DECISION DELEGATED TO DEVELOPMENT MANAGER

Application No: H14-0192-21 **Applicant:** Freshlinc

Proposal: Proposed roof mounted solar photovoltaic panels

Location: Freshlinc Wardentree Park Pinchbeck

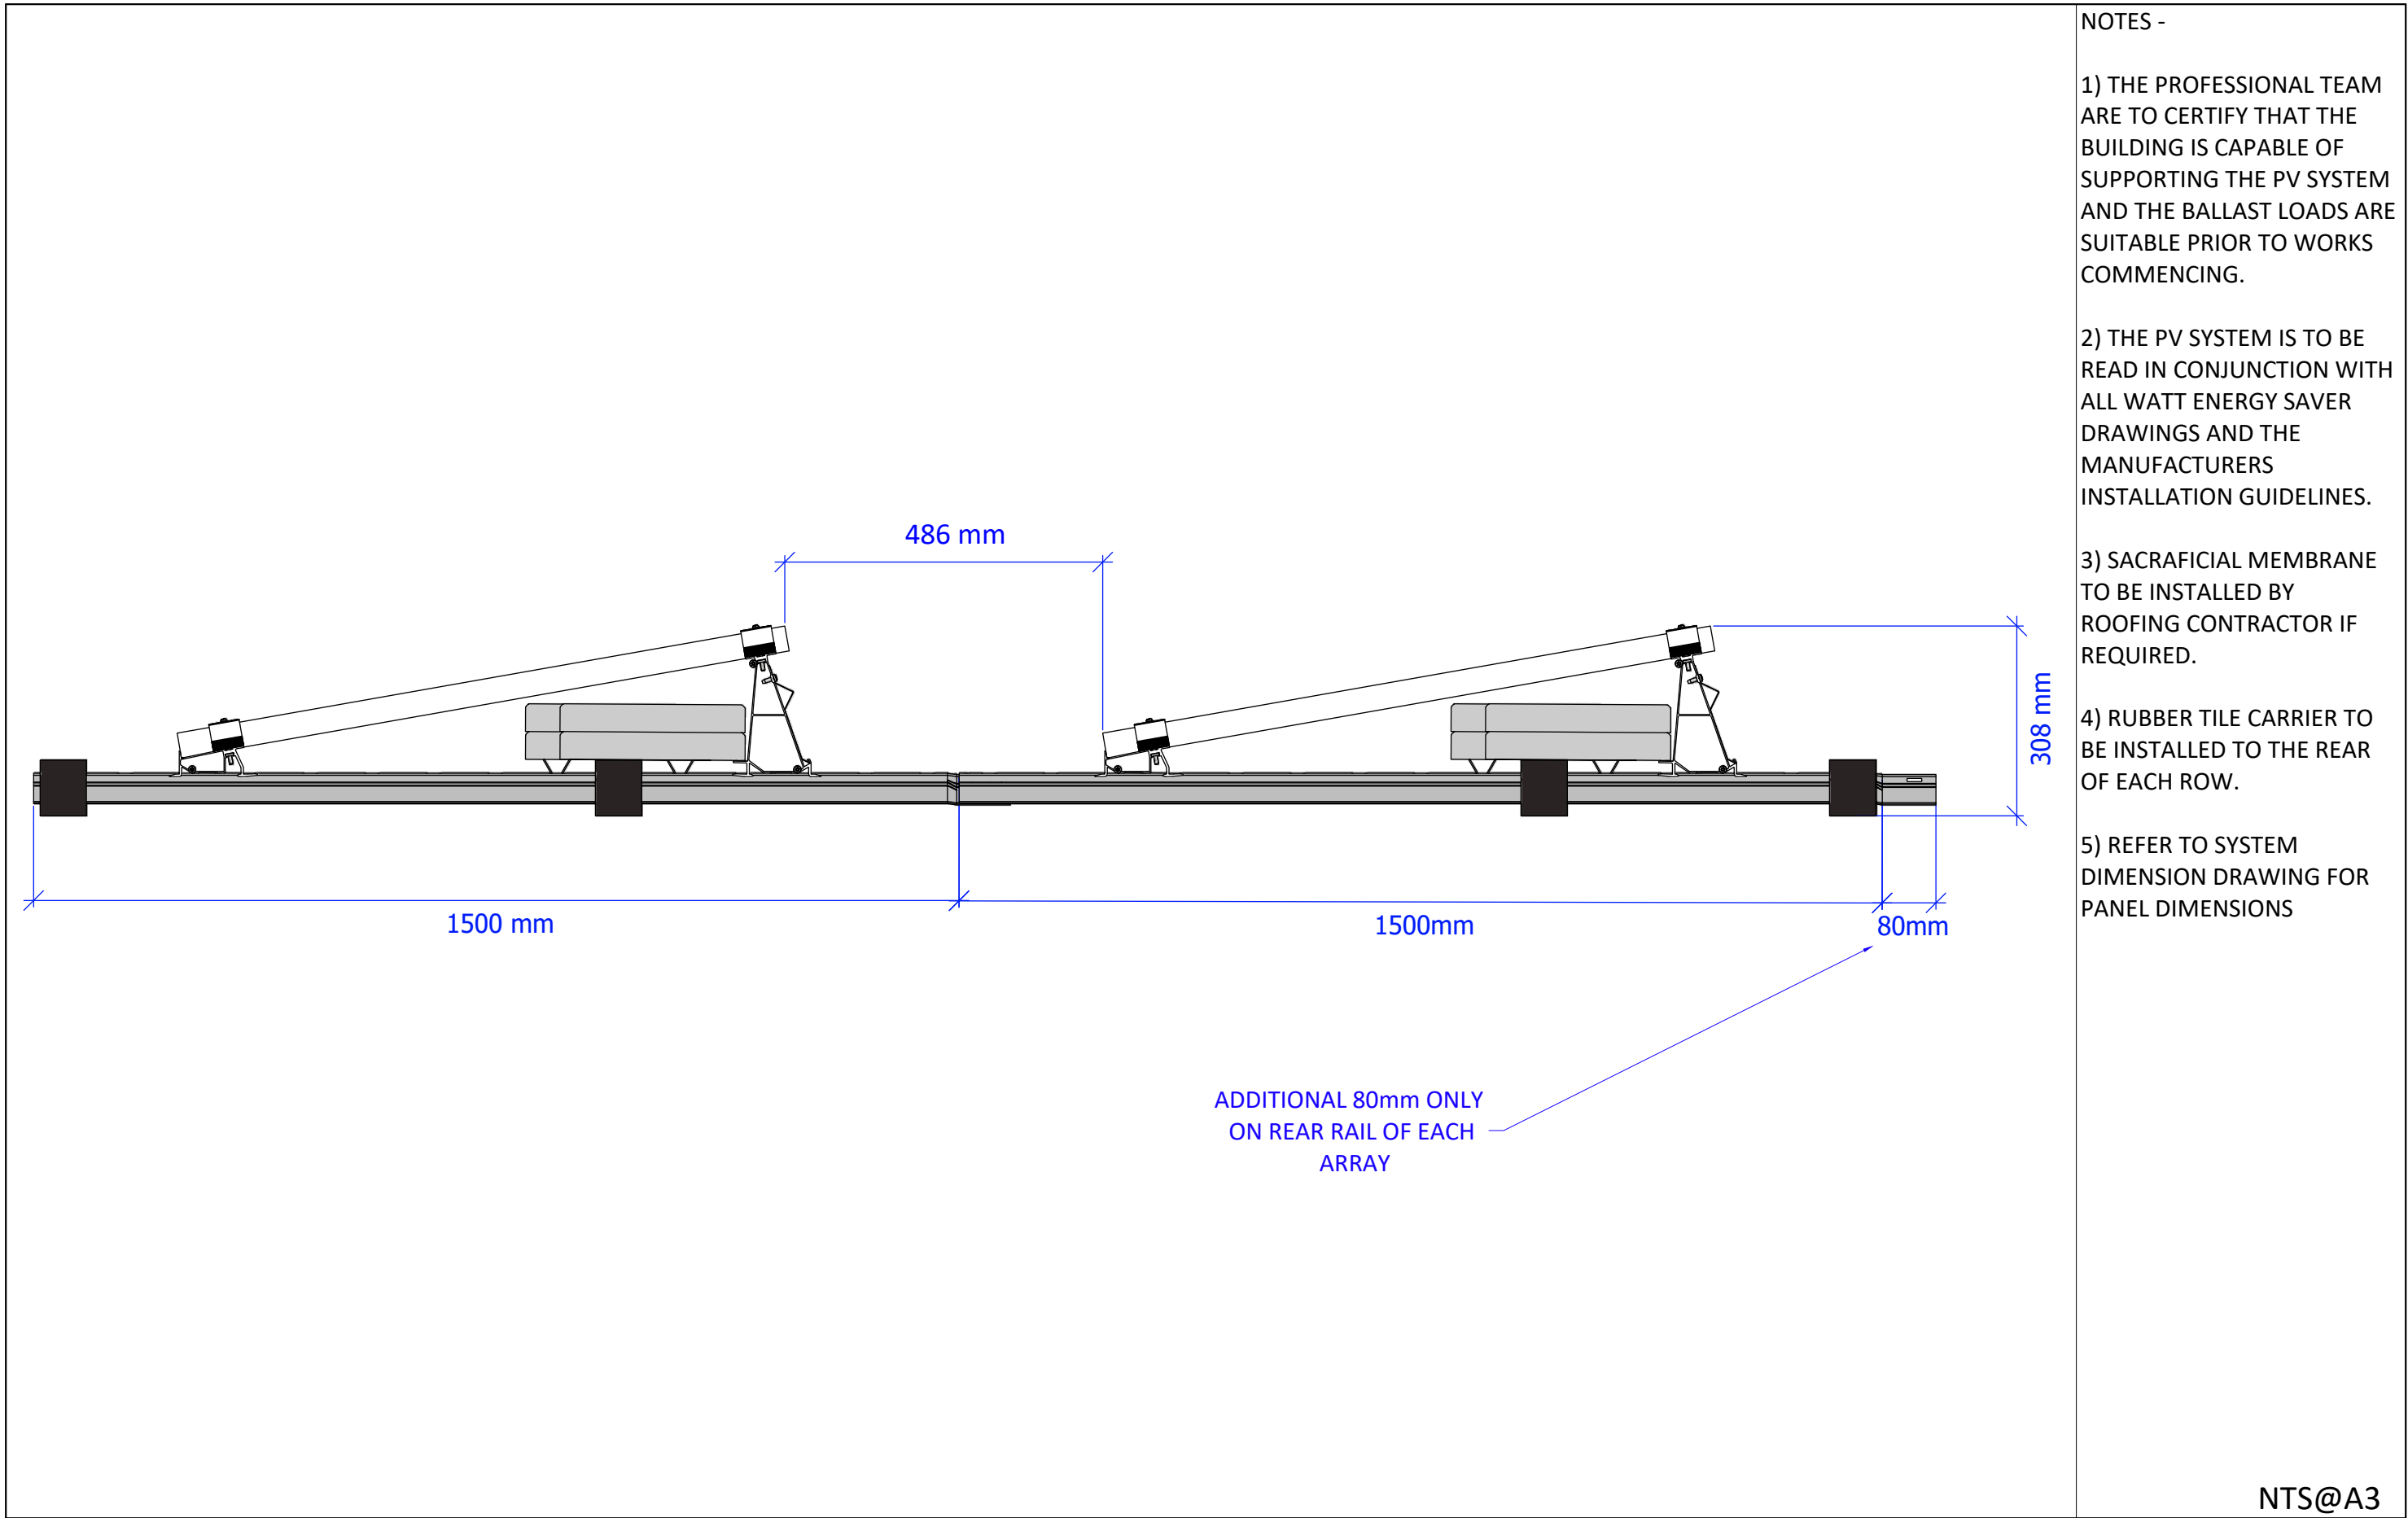
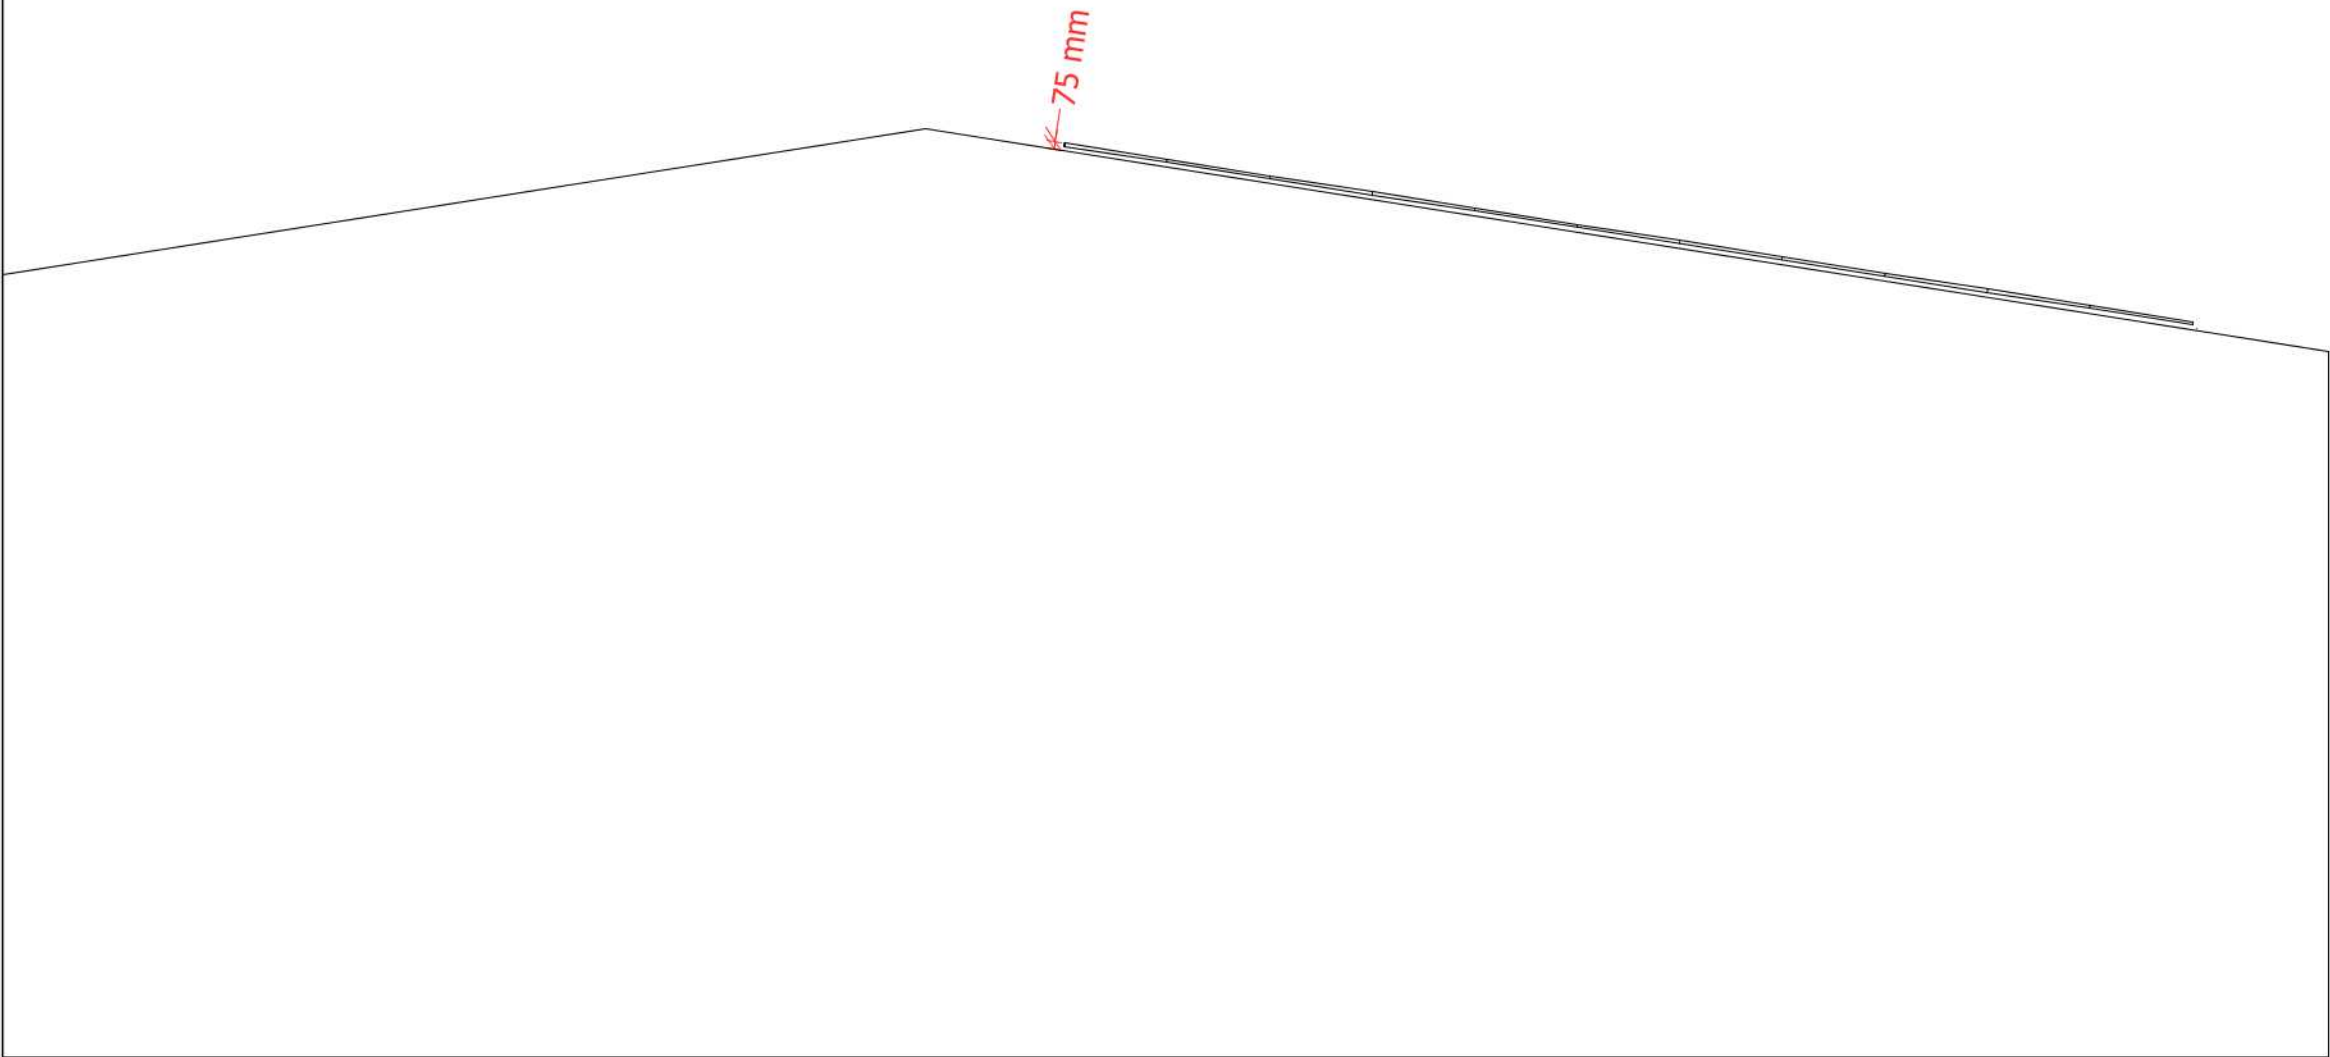
J.1.(a) The panels do not protrude more than 0.2 metres beyond the plane of the roof slope. Plan E-37-04 shows a mounting of the side section that is 0.075 metres beyond the plane of the roof.
